Our Case Number: ABP-318093-23

Re: Proposed road development at The Quay, Quay Street, Suir Island and Raheen Road The Quay, Quay Street, Suir Island and Raheen Road, Clonmel County Tipperary

Your Ref: **ABP-318093-23** Our Ref: **SID-TS-2023-035**

SID Application: Tipperary County Council: Suir Island Infrastructure Links Project - under Section 51(2) of the Roads Act 1993 (as amended) to An Bord Pleanála ('the Board') for approval in relation to a proposed road development consisting of the construction of: - North Plaza on The Quay/Quay St./Sarsfield St. Junction to Suir Island

SITE PLAN NORTH BRIDGE 1/250

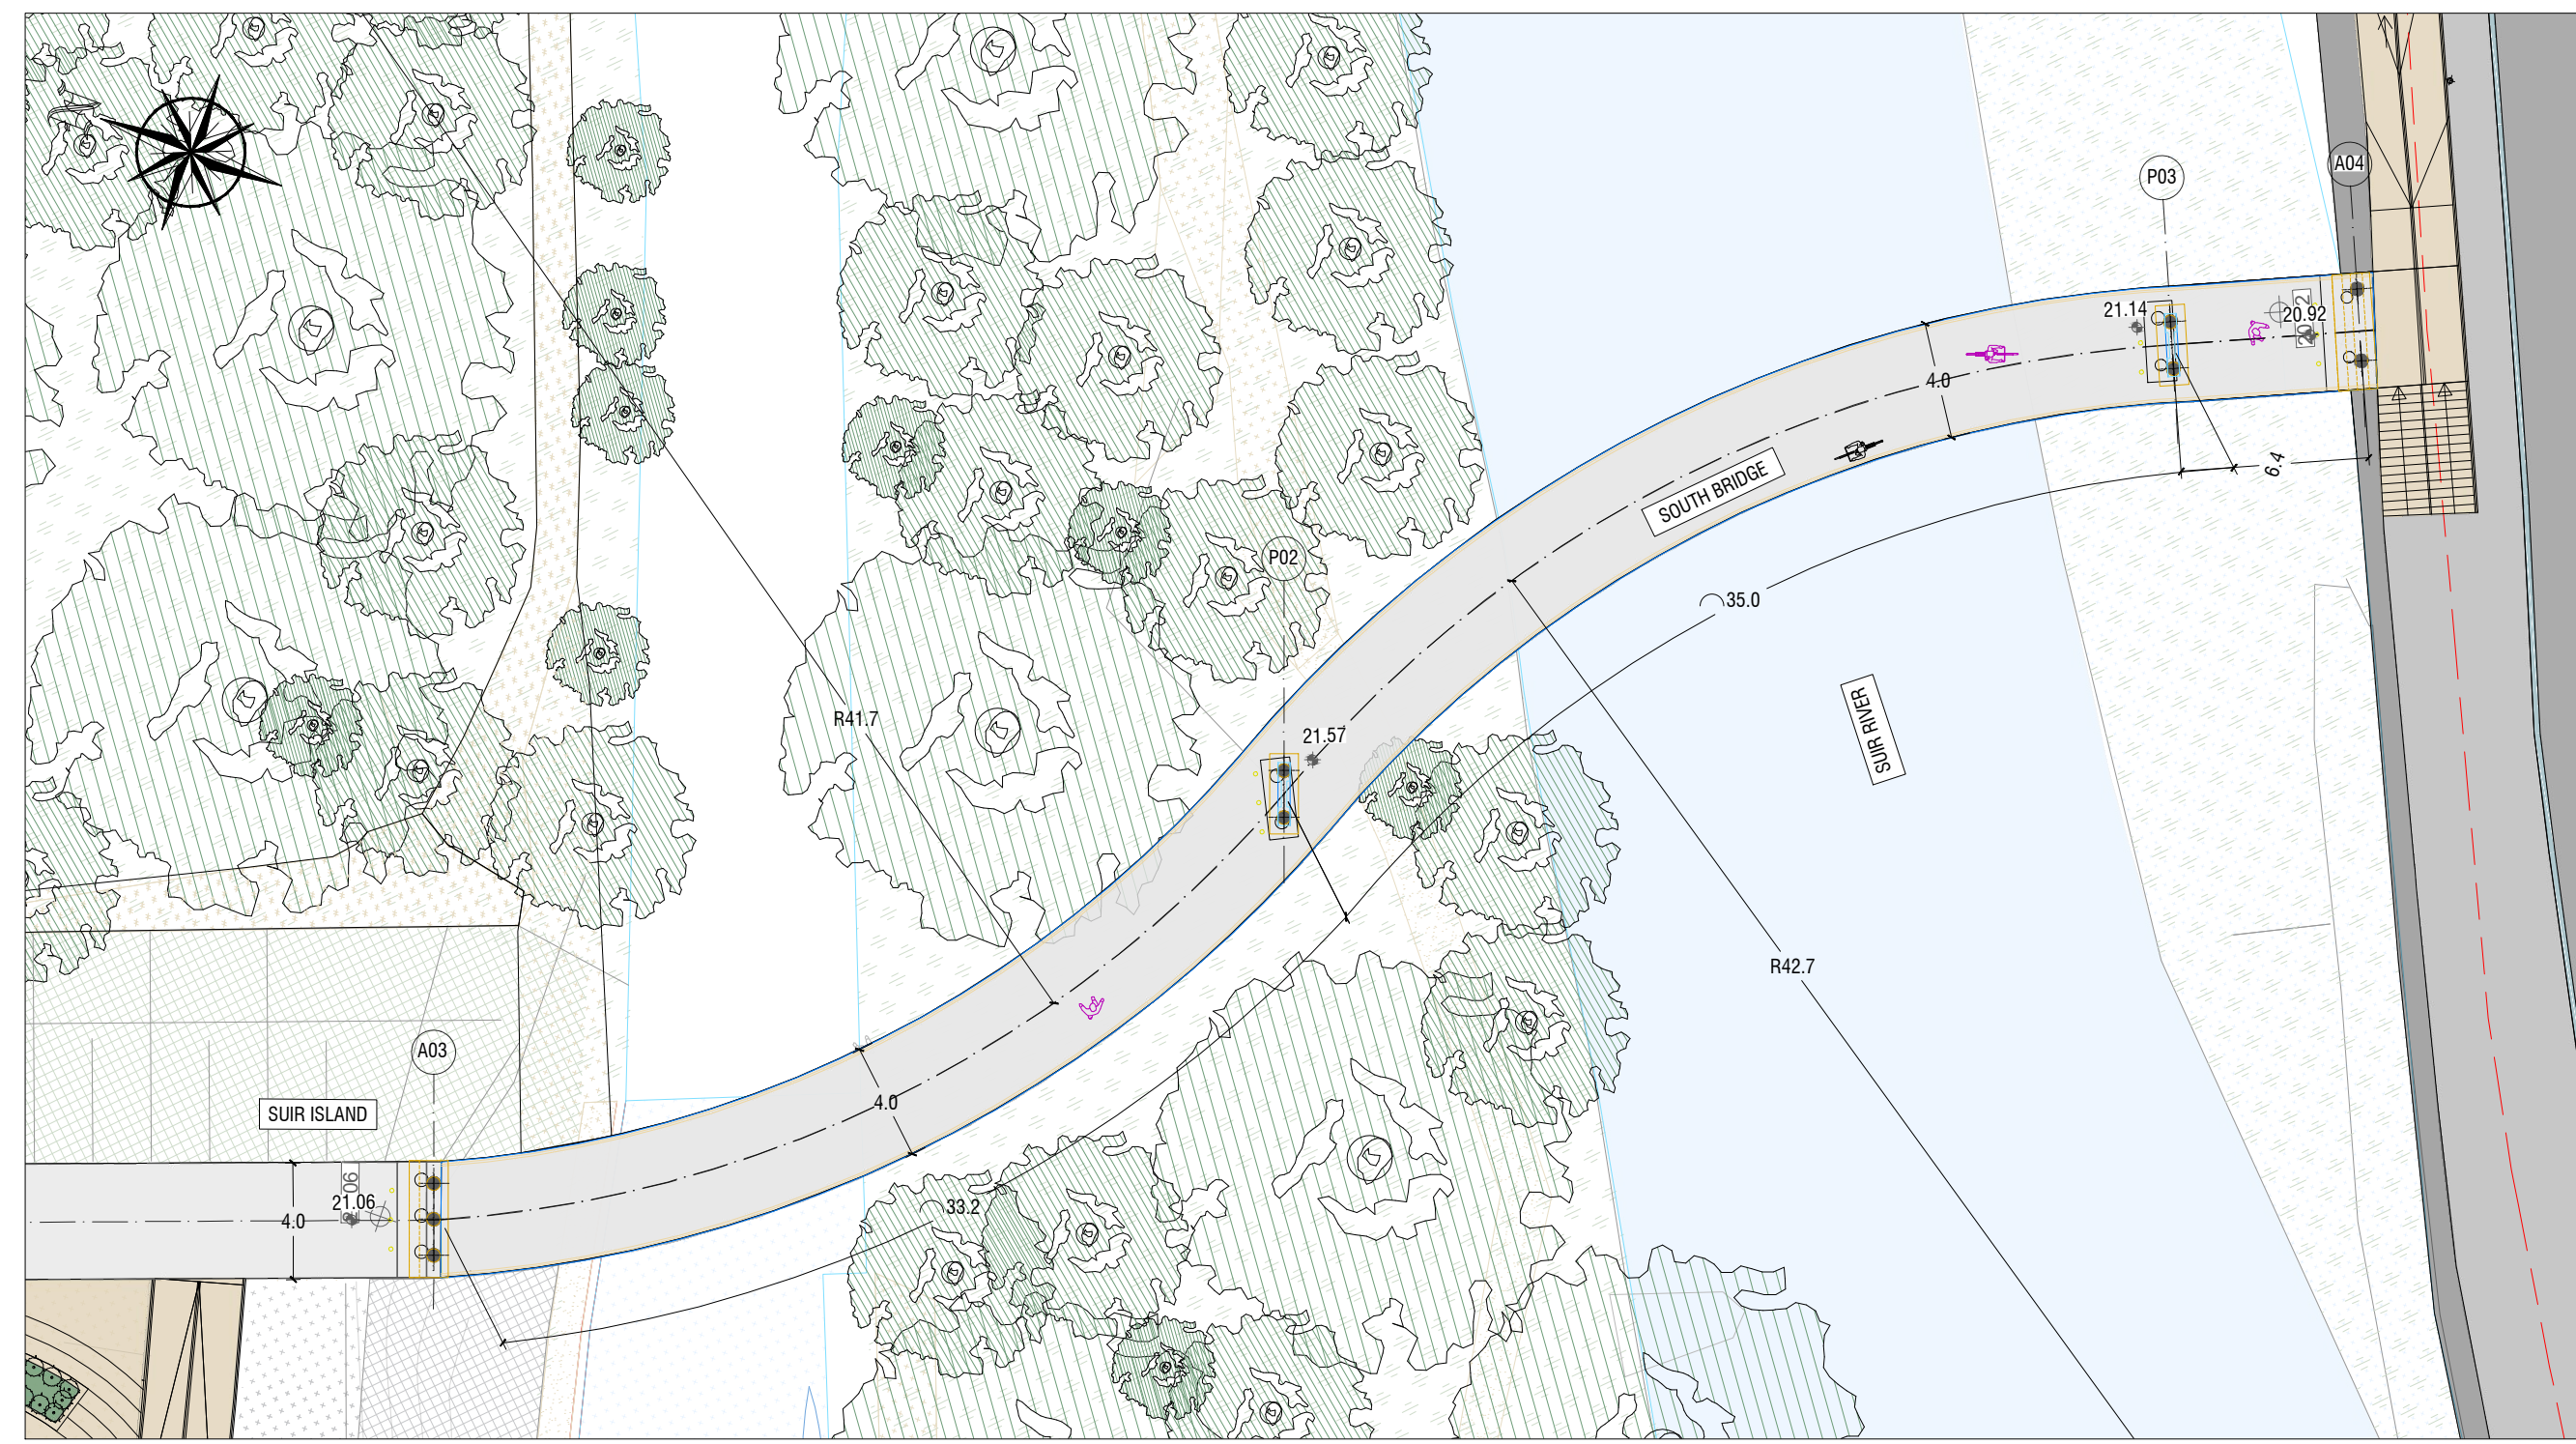
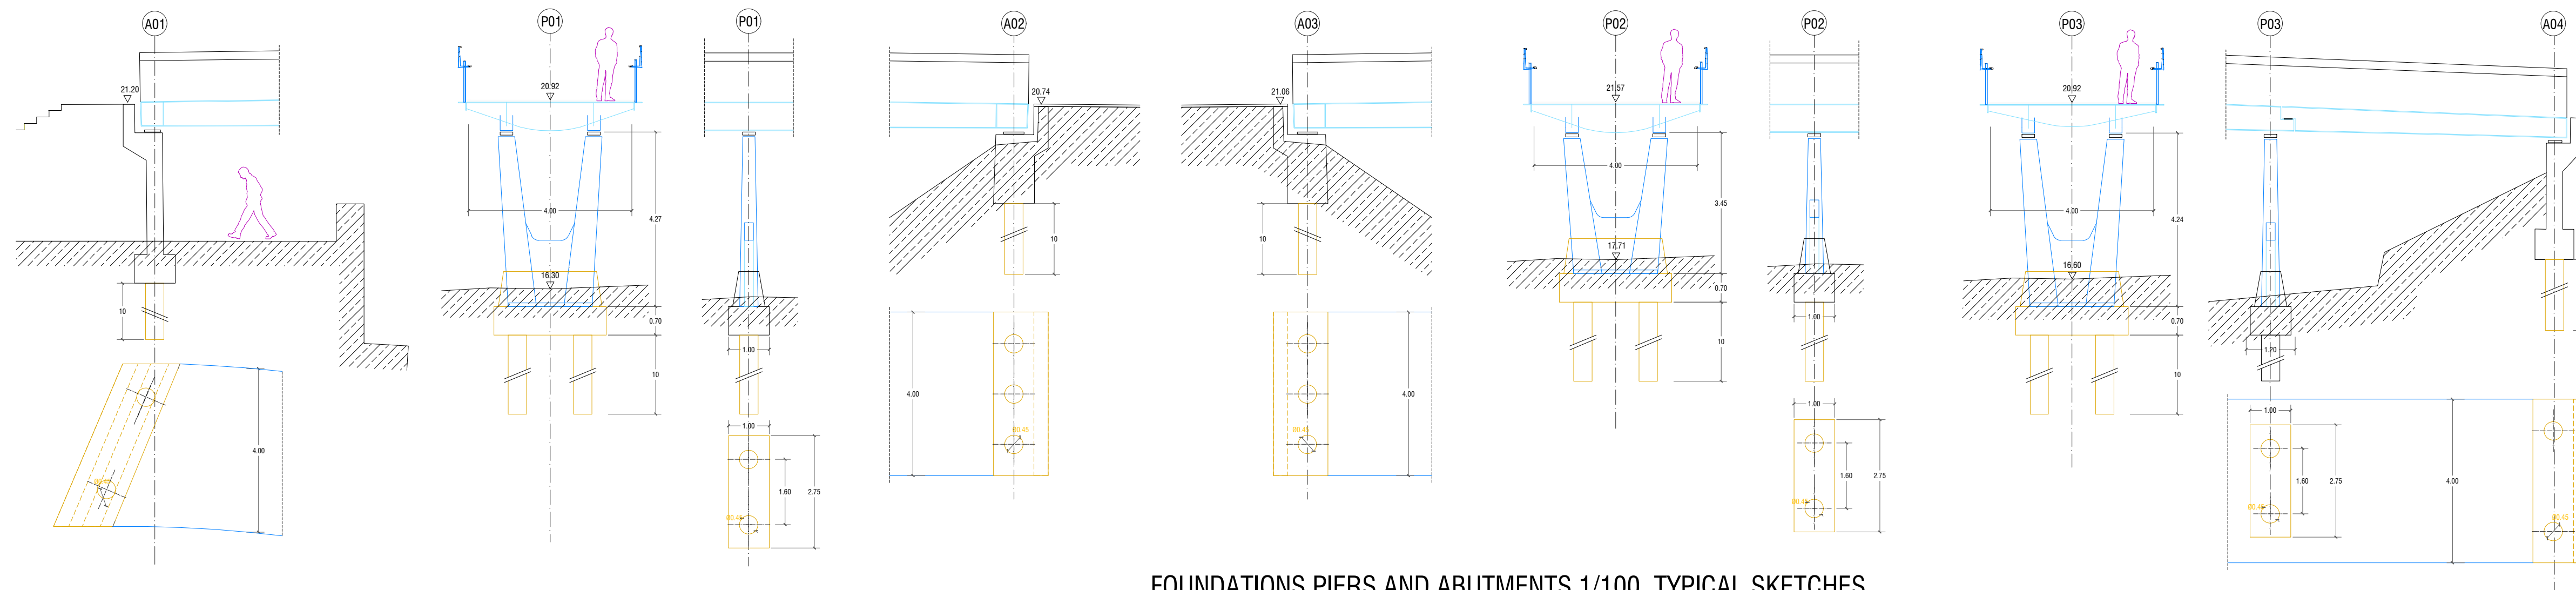
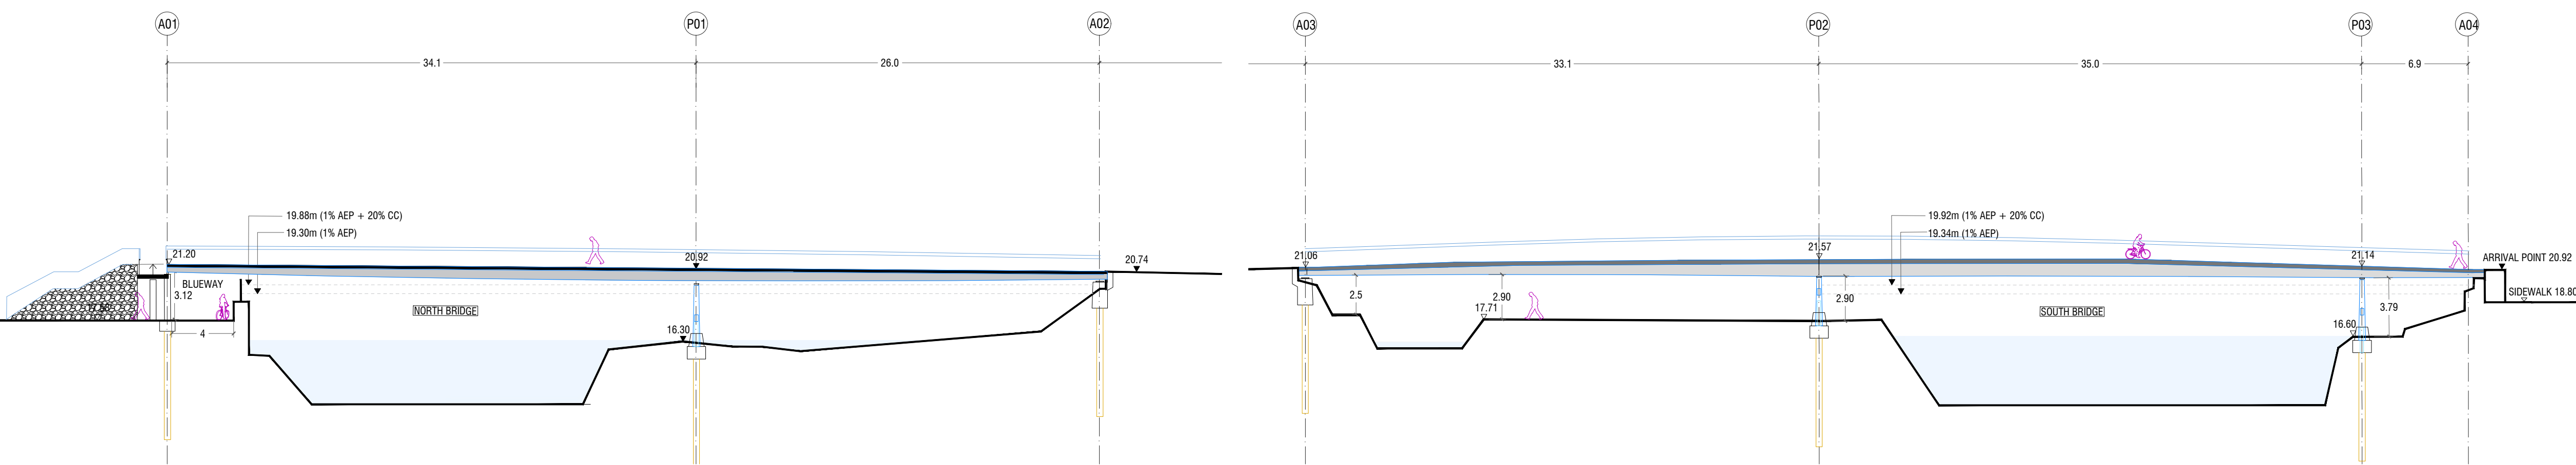
It is noted that Section 14.4.1 of the EIAR states that 'the pedestrian bridges on the north side and the south side of the river will be constructed on piled foundations in six locations

inserted on the banks of the river in the floodplain area. The construction of bridge supports will occur during low-flow periods in the summer. Localised sheet piling (circa 32 m2 area per pier) will be utilised around the pier locations to prevent the inundation of the works area and minimise groundwater ingress to the works area. There is a potential that deeply buried archaeological remains may be identified in the riverine silts excavated in the pier locations'. Section 14.5.1 of the EIAR proposes the following mitigation in relation to the construction of bridge supports: 'As part of the River Suir Flood Relief Scheme extensive works were carried out within and along the banks of the river Suir which was subject to underwater archaeological assessment and subsequent monitoring. Nothing of archaeological significance was identified. An underwater archaeological assessment is therefore not considered necessary as there will be no in-stream works proposed. It is recommended however that the enabling works for the piers in the floodplain be archaeologically monitored, as the riverine silts may have deeply buried deposits of archaeological potential'.

In light of the potential effects on underwater cultural heritage, as outlined above, it is recommended that a programme of pre-development underwater archaeological assessment should be undertaken. This should include underwater archaeological impact assessment of all in-stream works, including the North Bridge Pier (P01), enabling works, coffer dams and machinery movements that may effect the river channel and/or river banks, as set out below. These works should be carried out at the earliest possible stage to facilitate the embedding of any recommended further mitigation within the detailed design for the project, as necessary, in order to ensure the preservation in-situ of any identified underwater cultural heritage and to develop an informed archaeological strategy to be implemented in agreement with the Department

- b. The UAIA shall include a licenced dive/wade assessment, accompanied by a hand-held metal detection survey, centred on (but not confined to) the area(s) where works are proposed within or immediately proximal to the river channels, including the proposed locations of the North Bridge Pier (P01), enabling works, coffer dams and machinery movements that may effect the river channel and/or river banks. The dive/wade assessment and metal detection survey shall be undertaken by a suitably licenced and experienced underwater archaeologist. All identified underwater cultural heritage shall be surveyed (photographic, descriptive, photogrammetric) in detail as part of the assessment. A Dive/Survey licence (Section 3 1987 National Monuments Act) and Detection Device consent (Section 2 1987 National Monuments Act) will be required for the dive/wade survey and metal detection, respectively. Licenses should be applied for to the Department and should be accompanied by a detailed method statement. Note a period of 3-4 weeks should be allowed to facilitate processing and approval of the licence applications and method statement. All archaeological wading/diving should comply with the Health and Safety Authority's Safety, Health and Welfare at Work (Diving) Regulations 2018/2019.

report shall include a comprehensive Archaeological Impact Statement (AIS) that comments on the degree to which the extent, location and levels of all proposed works (including pier structures, abutments, sheet piling, coffer dams, ground disturbances, foundations, service trenches and other sub-surface works including Site Investigation works) required for the development will impact upon any underwater cultural heritage, archaeological materials, objects and/or areas of archaeological potential that have been identified. The AIS shall describe the potential impact(s) of all proposed in-stream development, access and ingress routes to the river, and shall also assess any proposed additional Site Investigation/Geotechnical impacts and potential secondary/indirect impacts such as scouring resulting from changes in hydrology. The AIS should be illustrated with appropriate plans, sections and photographs that clearly describe any adverse effect(s) of the development on the underwater cultural heritage and proposals for their mitigation. Mitigation may include recommendations for redesign to allow for full or partial preservation in situ, the institution of archaeological exclusion zones, further wade/dive surveys, test-excavations, excavations ('preservation by record') and/or monitoring, as deemed appropriate. The Department will advise with regard to these matters. No construction works shall commence until after the UAIA has been submitted and reviewed. All recommendations will require the agreement of the Department. In default of agreement on any of these requirements, the matter shall be referred to An Bord Pleanála for determination.
